DRB Application No.: 06DRB-01551 (P&F)
 Project Name: LANDS OF BURTIN & RYAN
 Agent: Jack's High Country

**CITY OF ALBUQUERQUE
PLANNING DEPARTMENT
November 8, 2006
DRB Comments**

Re: Lots 13-A-1, 13-B-1, 14-A1-A2 & 17-A, Lands of Burtin & Ryan/p&f

DEVELOPMENT REVIEW BOARD
UTILITY DEVELOPMENT
Standard Comment Sheet

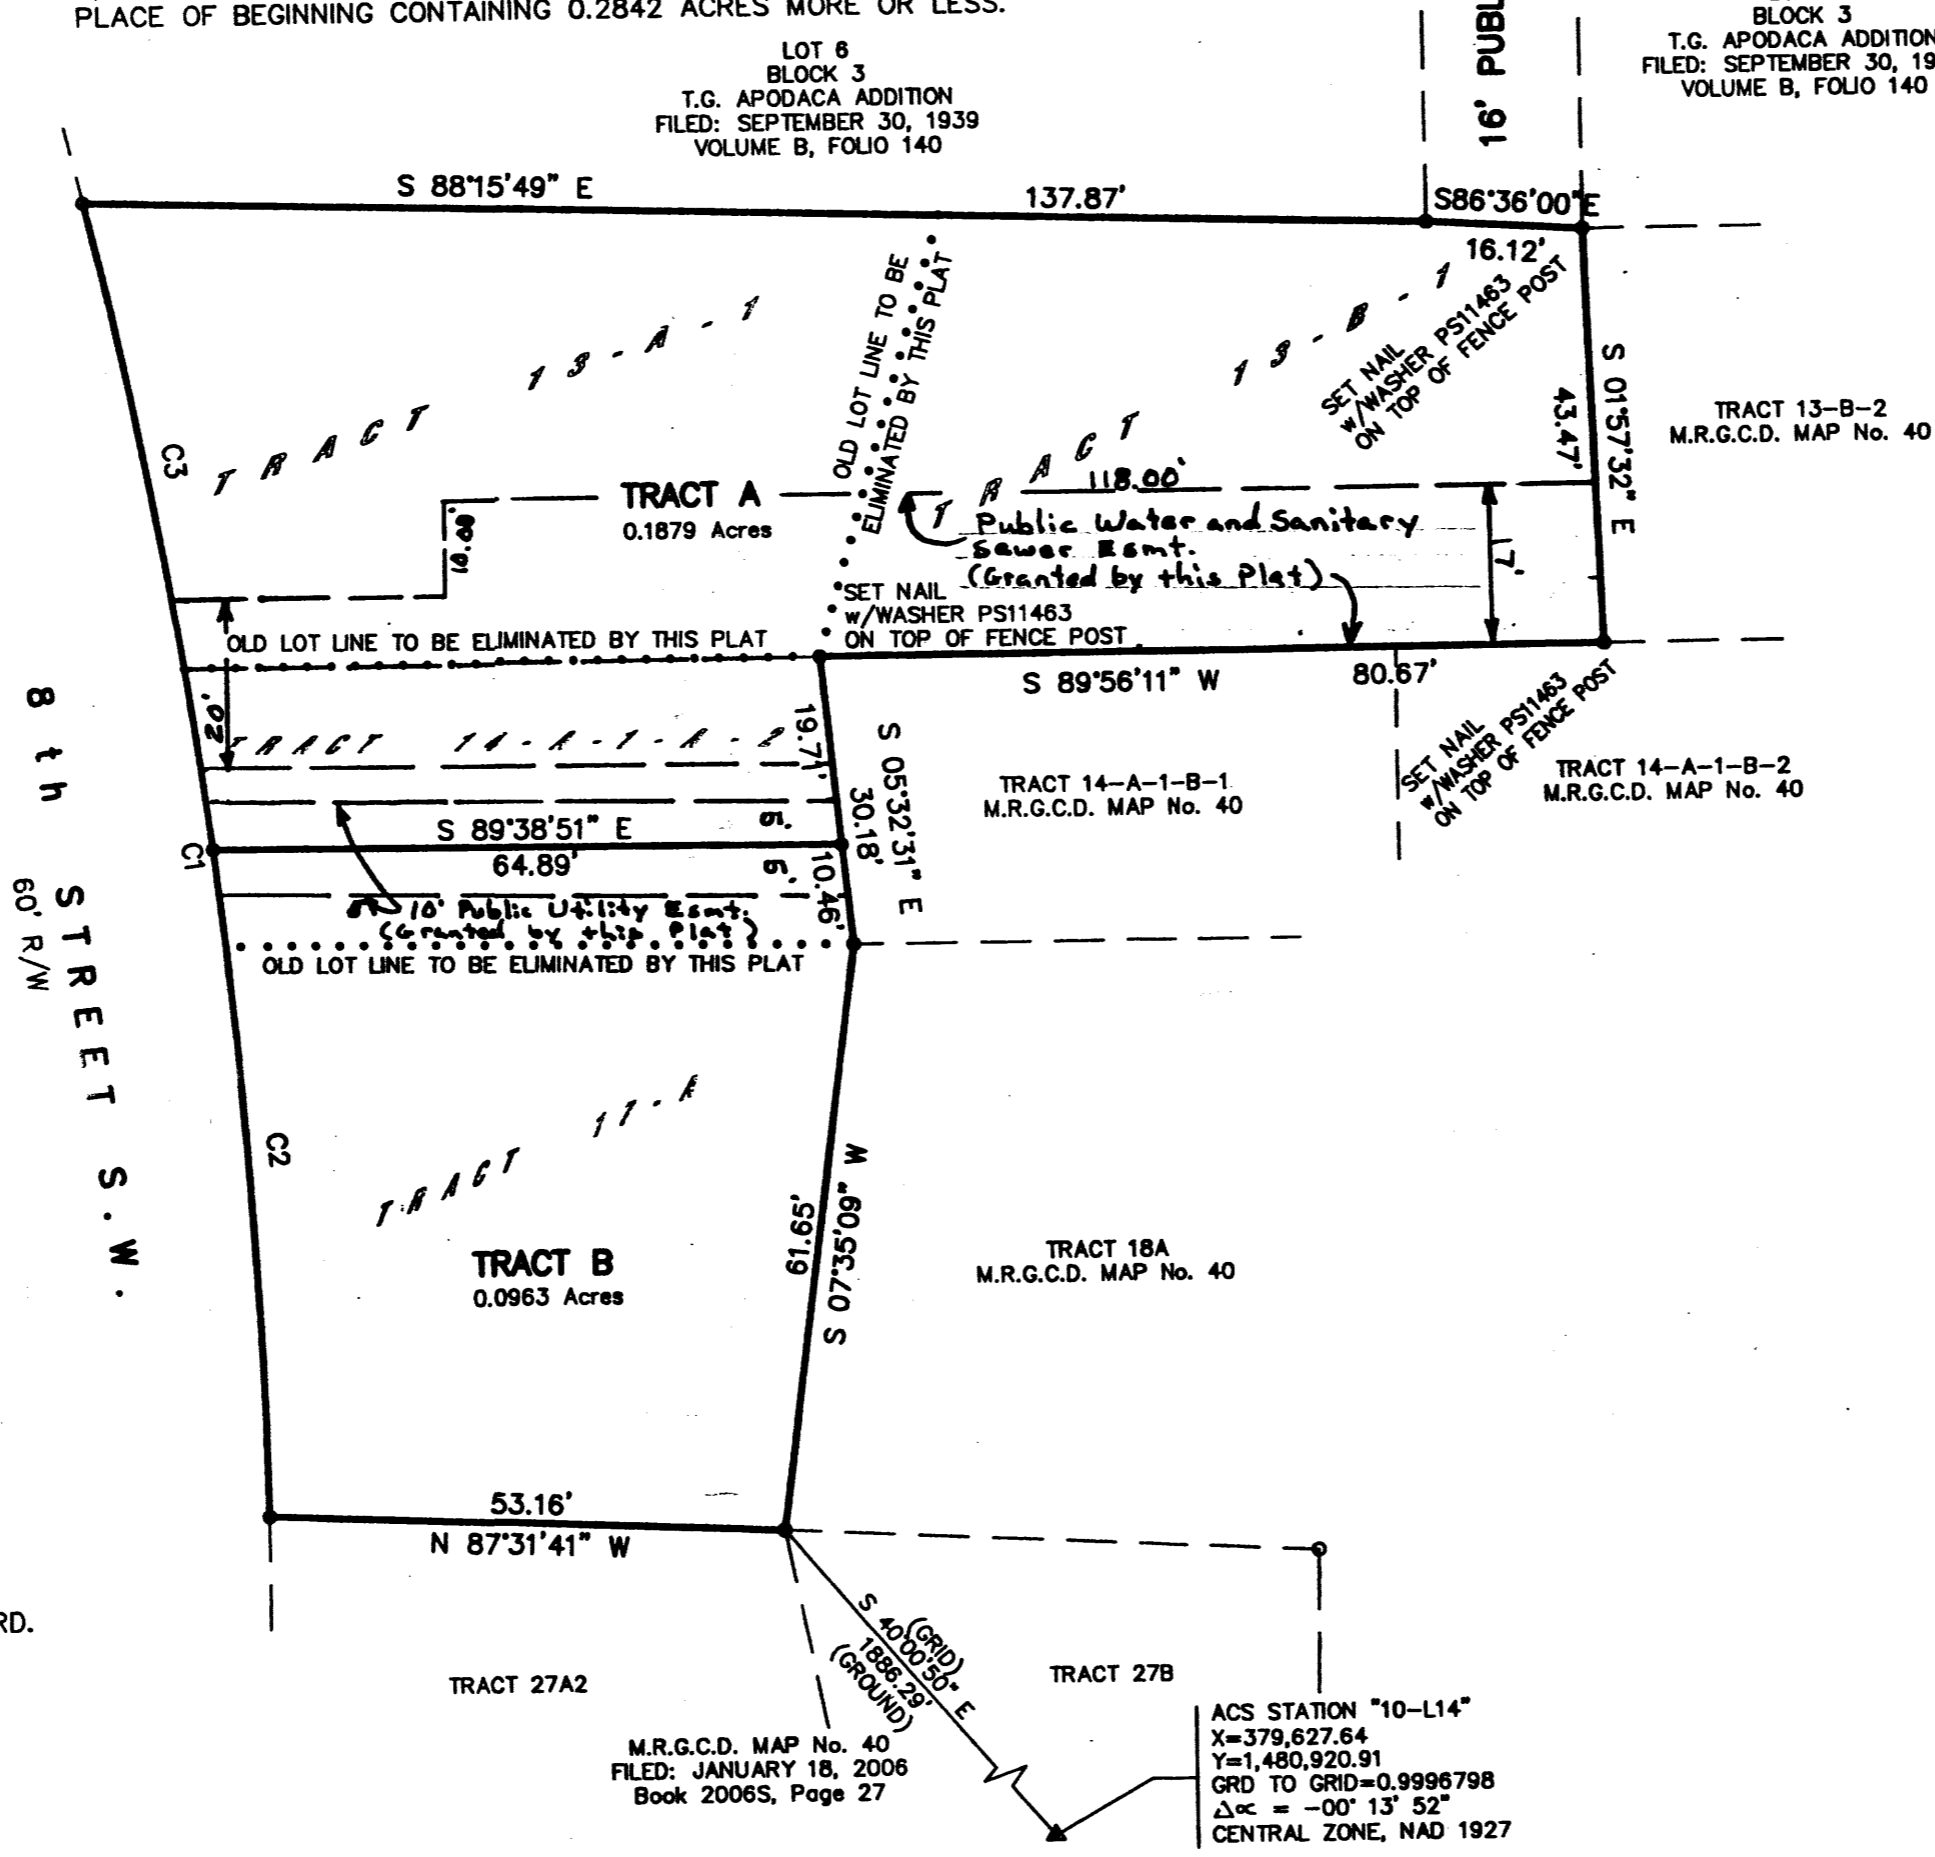
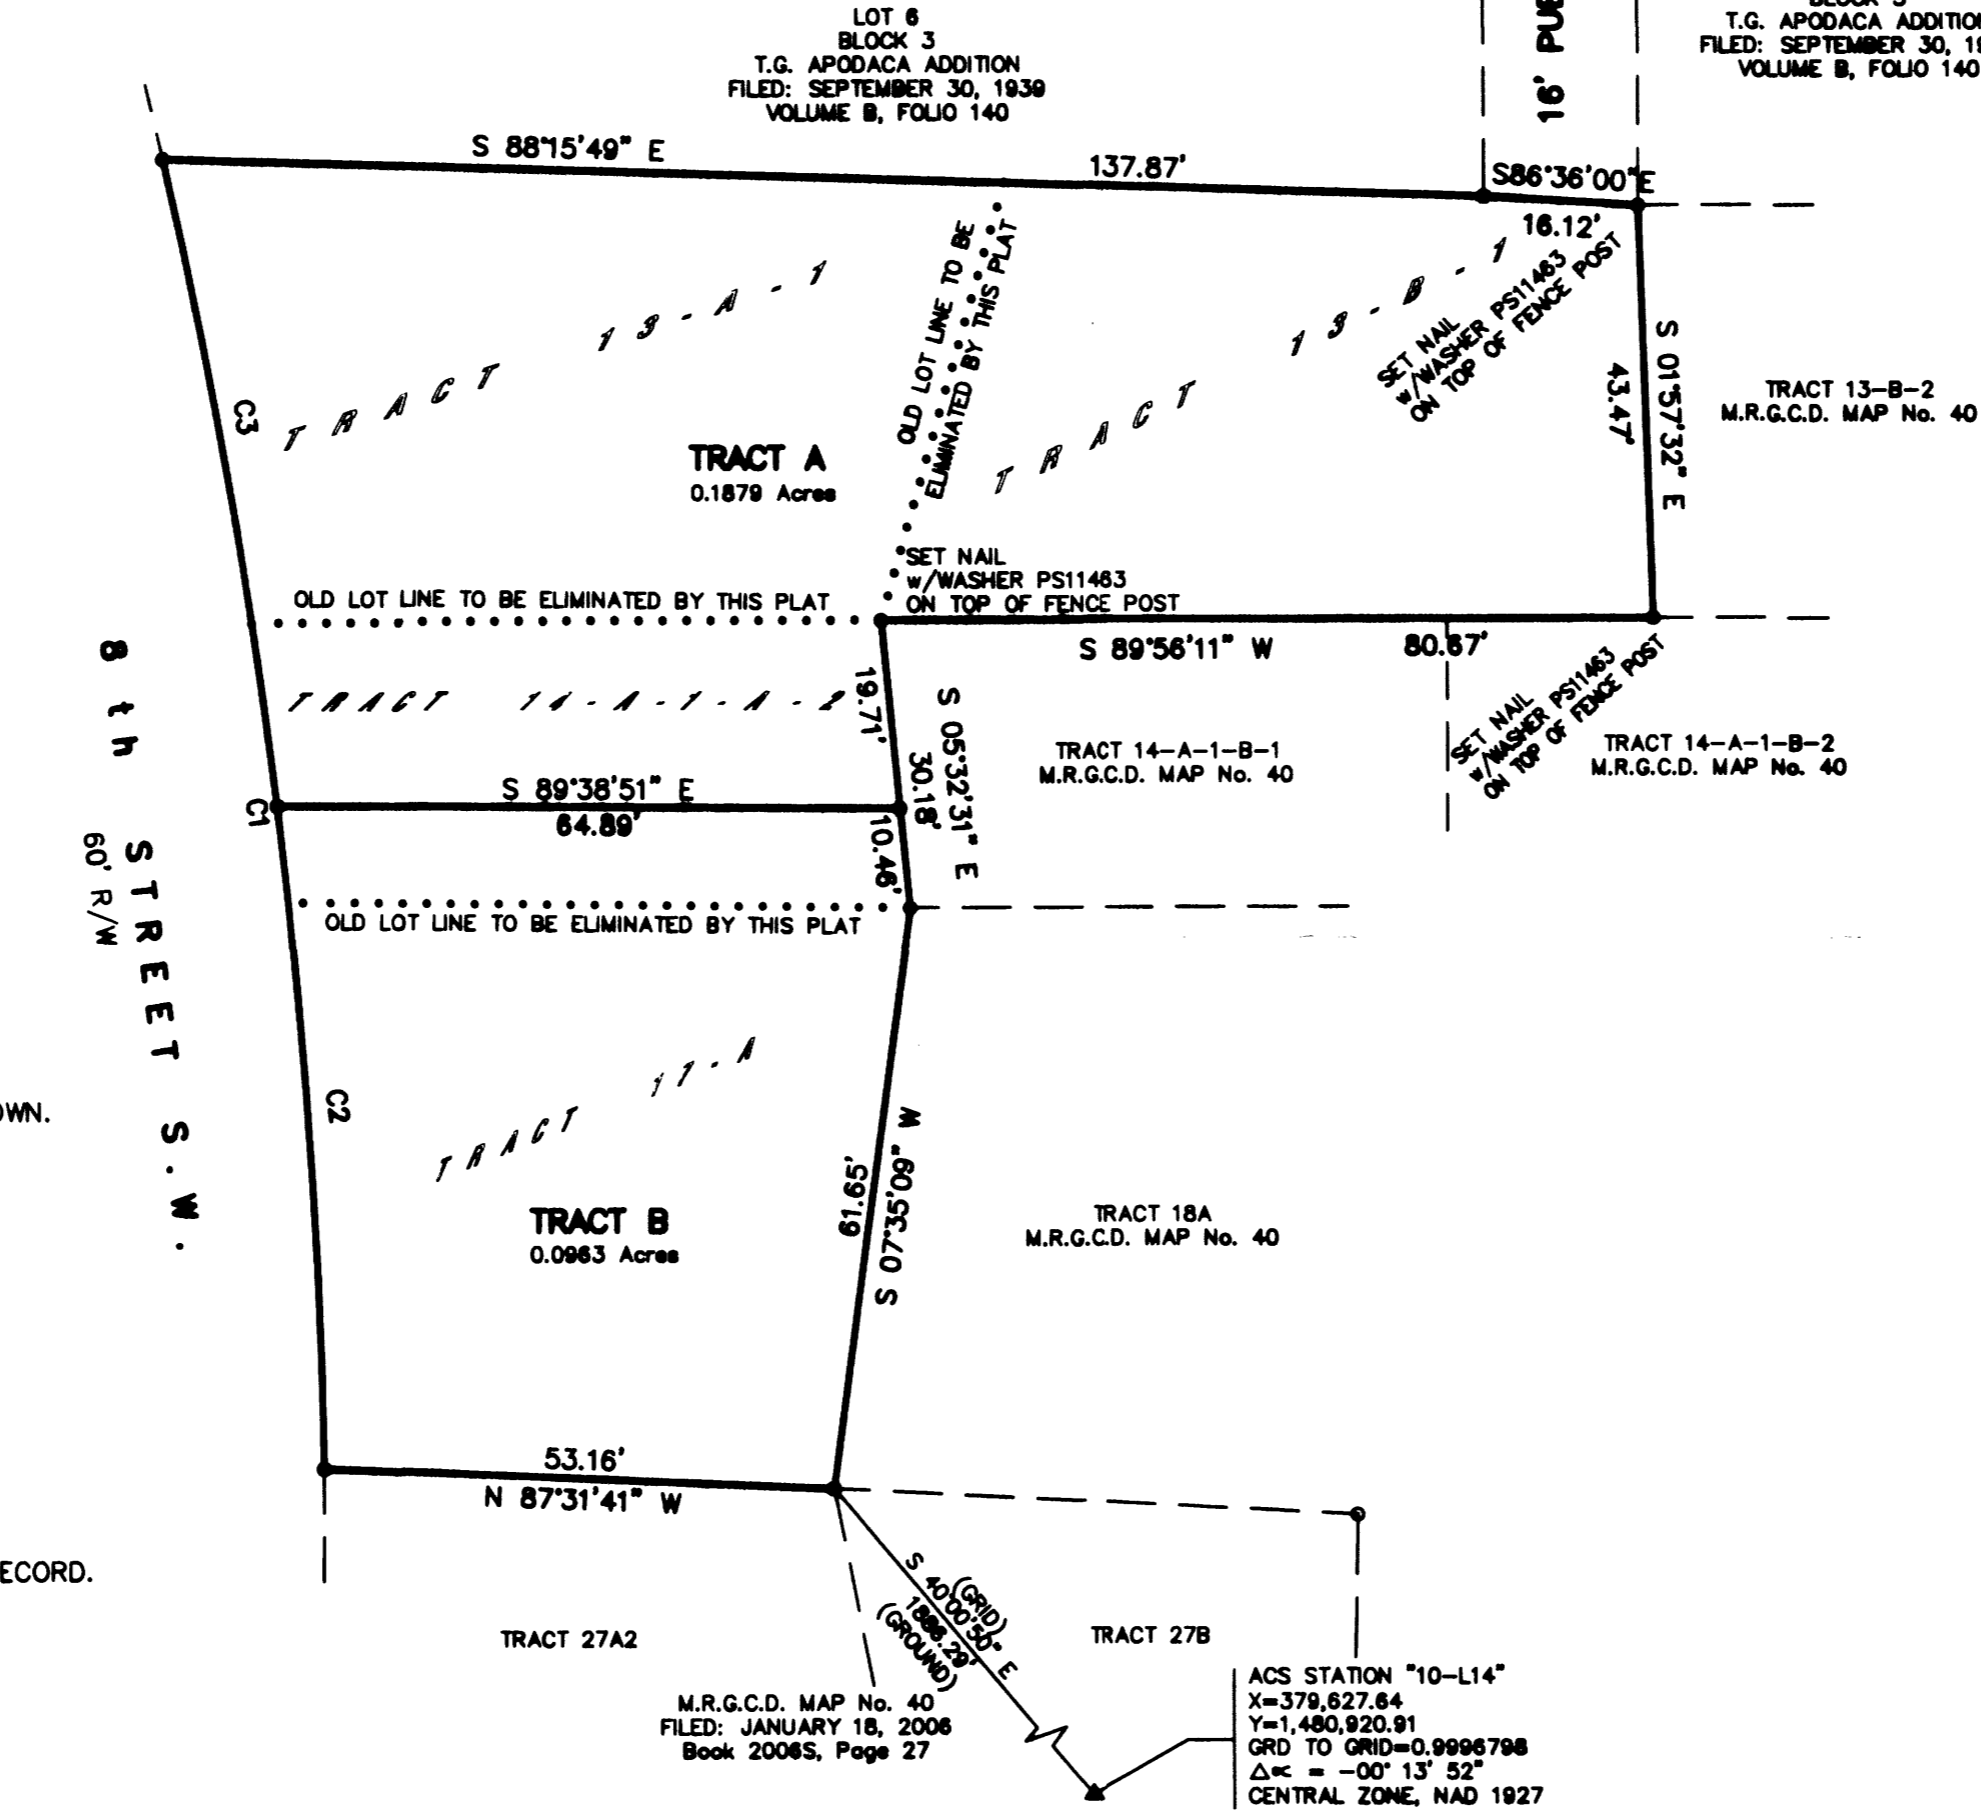
UTILITIES: Restore Water/Sewer Easement Width/Location

1. As a condition of replat, provide an easement for the existing 6" cast iron water line and existing 8" sanitary sewer line that crosses thru this parcel of land. For additional information, refer to the attached maps.
